City of Portland, Maine - Building or Use Permit Application
 389 Congress Street, 04101 Tel: (207) 874-8703, Fax: (207) 874-8716

Permit No: 04-0816	Issue Date:	CBL: 112 A013001
------------------------------	--------------------	----------------------------

Location of Construction: 7 Deerfield Rd	Owner Name: Duncan Gayle P	Owner Address: 7 Deerfield Rd	Phone: 799-5467
Business Name:	Contractor Name: Pock Carpentry	Contractor Address: 86 Grand Street South Portland	Phone: 2077995462
Lessee/Buyer's Name	Phone:	Permit Type: Alterations - Dwellings	Zone:

Past Use: Roofed porch on single family home	Proposed Use: Deck w/ railings on single family home	Permit Fee: \$57.00	Cost of Work: \$4,000.00	CEO District: 1
Proposed Project Description: Construct deck-replace decking,posts,rails-add screens		FIRE DEPT: <input type="checkbox"/> Approved <input type="checkbox"/> Denied	INSPECTION: Use Group: Type	
		Signature:	Signature:	
PEDESTRIAN ACTIVITIES DISTRICT (P.A.D.)				
Action: <input type="checkbox"/> Approved <input type="checkbox"/> Approved w/Condition <input type="checkbox"/> Denied				
		Signature:	Date:

SCALE 1" = 10'-0"
 MAP 112
 LOT 13

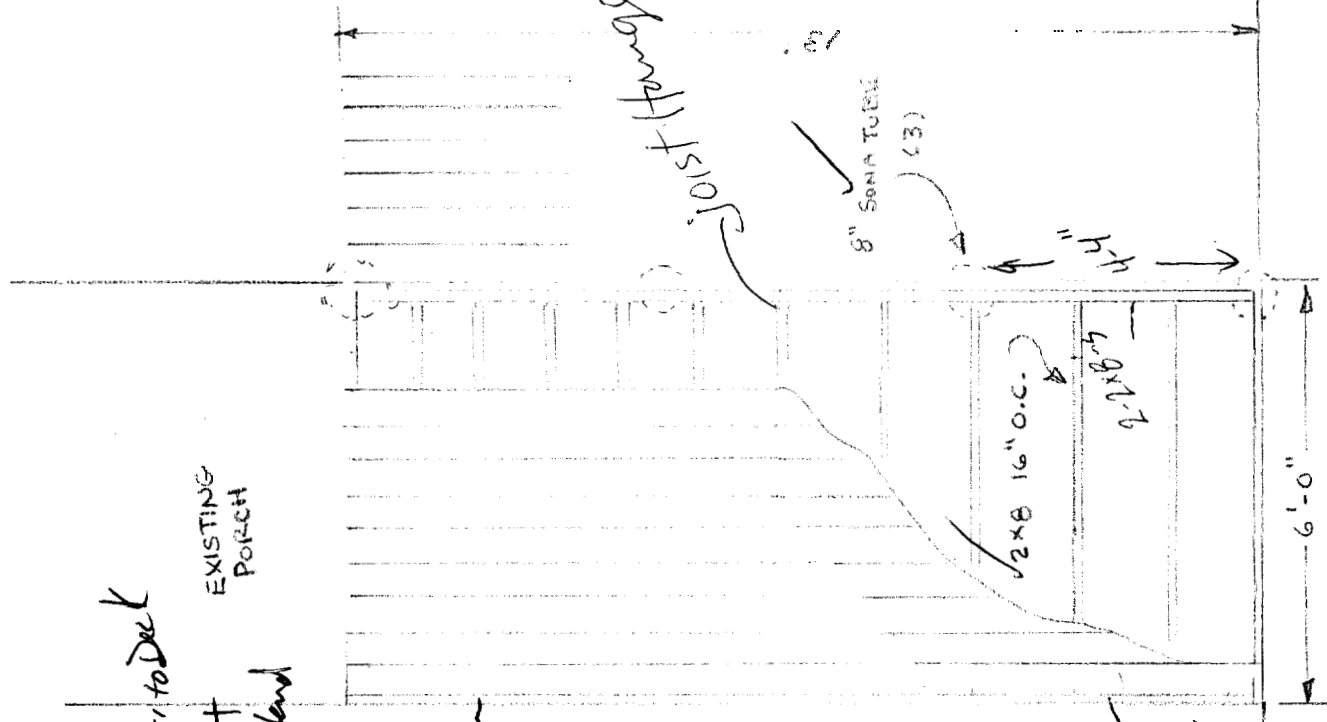
1) The rear stairs from the deck is not shown on your submitted plan. THE STAIRS MAY NOT extend closer than 20 feet from the rear property line. The Code Enforcement Officer will be confirming the required 20 foot rear setback requirement.			
Dept: Building	Status: Approved with Conditions	Reviewer: Jeanine Bourke	Approval Date: 07/19/2004
Note: 7/19/04 spoke w/Mike P. On phone to review code issues on plans. See notes on plans to reflect changes, ok to issue			Ok to Issue: <input checked="" type="checkbox"/>
